KITTITAS COUNTY FIRE MARSHAL'S OFFICE

Re: Central Cascade (BL-12-00032)

After conducting a review of the above named project, I have the following comments:

BOUNDARY LINE ADJUSTMENT
 PREPARED FOR
 CENTRAL CASCADES LAND CO INC
 A PORTION OF THE EAST 1/2 OF SECTION 21,
 TOWNSHIP 20 NORTH, RANGE 15 EAST, W.M.

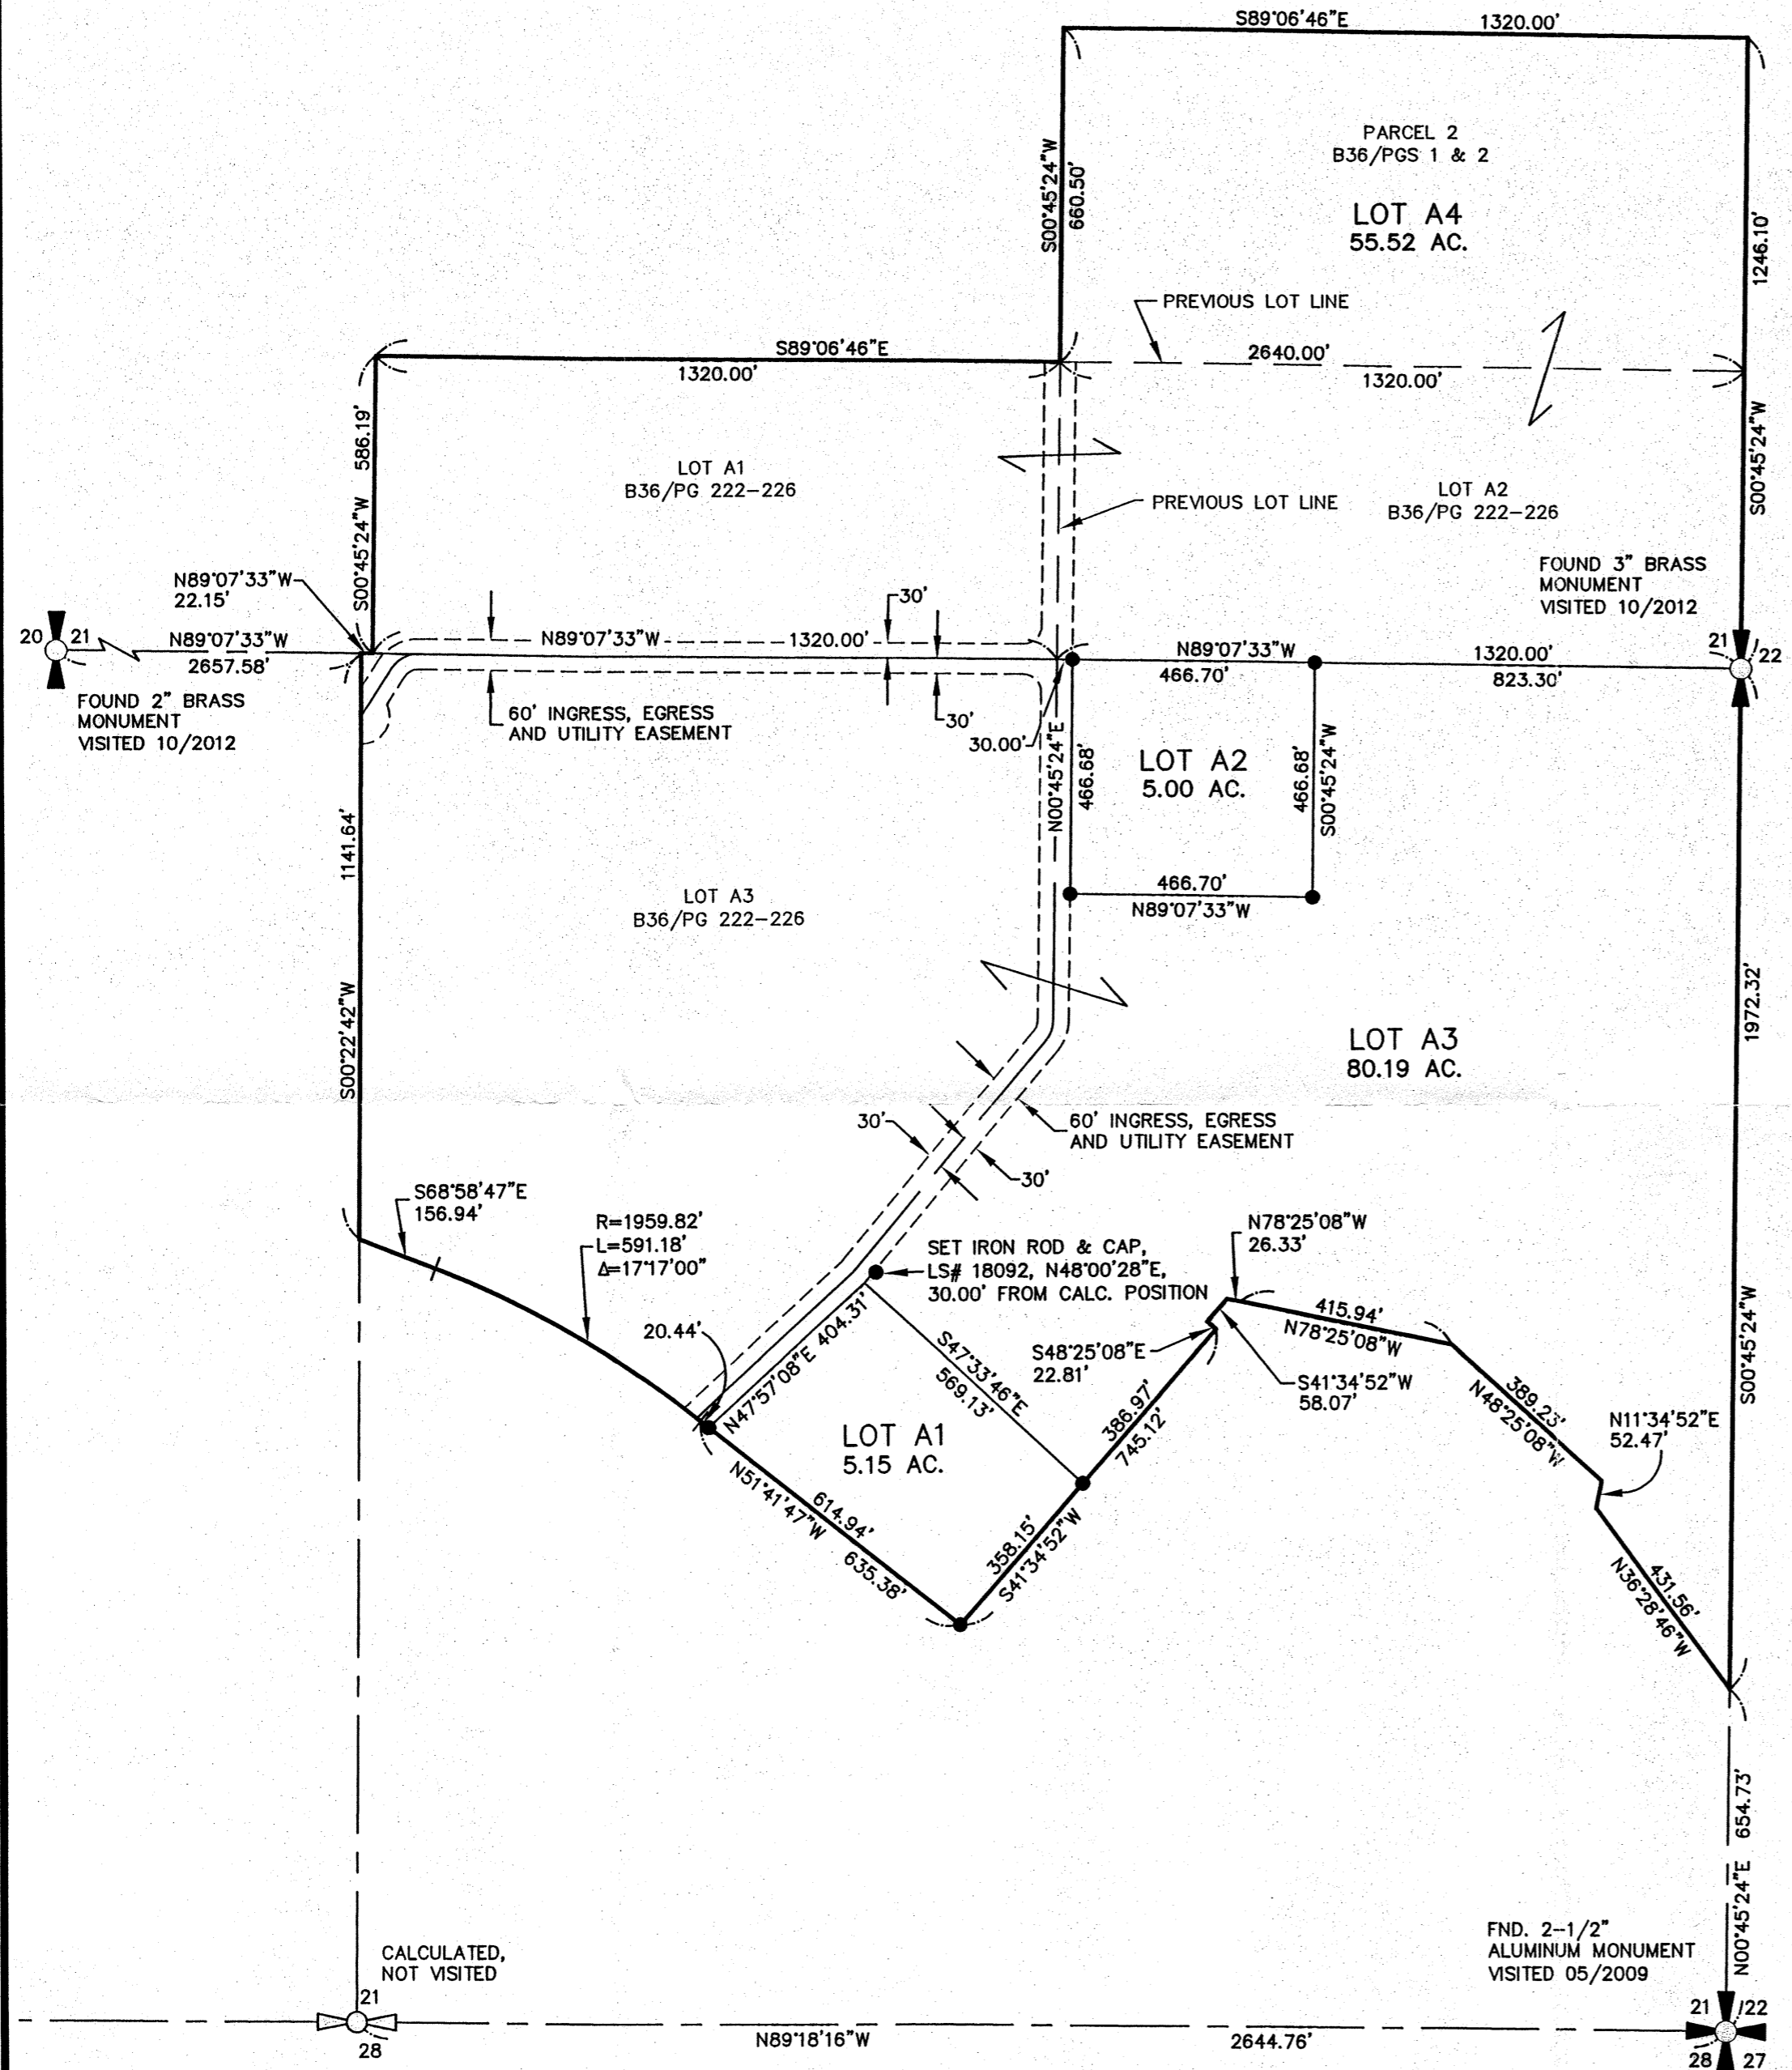
- Any new roads that are created are to comply with Kittitas County Road Standards and the International Fire Code.
- Ensure that boundary line adjustments do not infringe upon existing structures, to include propane tanks, etc.
- All future development must comply with the International Fire Code.
